P/119/21/DOC

253-255 Pagham Road Pagham PO21 3QB

Approval of details reserved by condition imposed under ref W/4001476 (P/58/19/PL) relating to Condition Nos 5 - Construction & Environmental Management Plan, 6 - surface water drainage, 7 - maintenance & management of surface water drainage and 14 - materials, finishes & detailing for external walls and roofs.

SCHEDULE OF MAIN MATERIALS:-

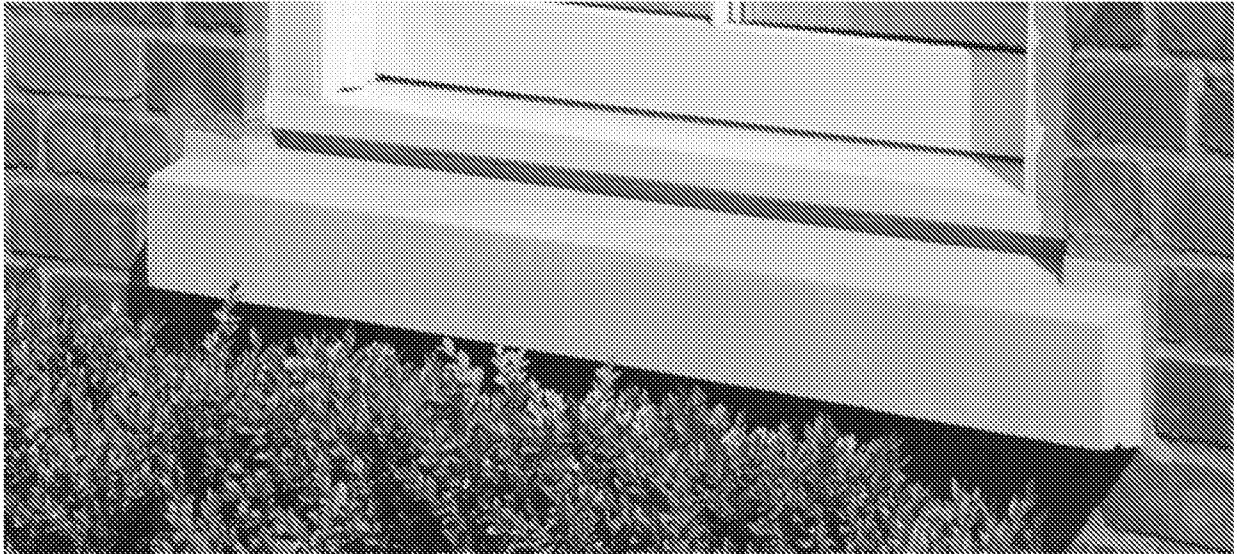
I note in the original planning application that the application form describes the windows and doors as being or timber construction. It is therefore disappointing that the current ones proposed are UPVC. It is also not fully clear what is meant by 'generally white UPVC'. Please can this be confirmed?

The other materials seem to be generally acceptable, although I would want to make sure that the roof tiles would be mixed on all of the roofs or divided between the properties. On a computer screen, the colours appear to be almost contrasting i.e. light brown and a strong red/orange colour. Otherwise, the fact that they are clay tiles is acceptable.
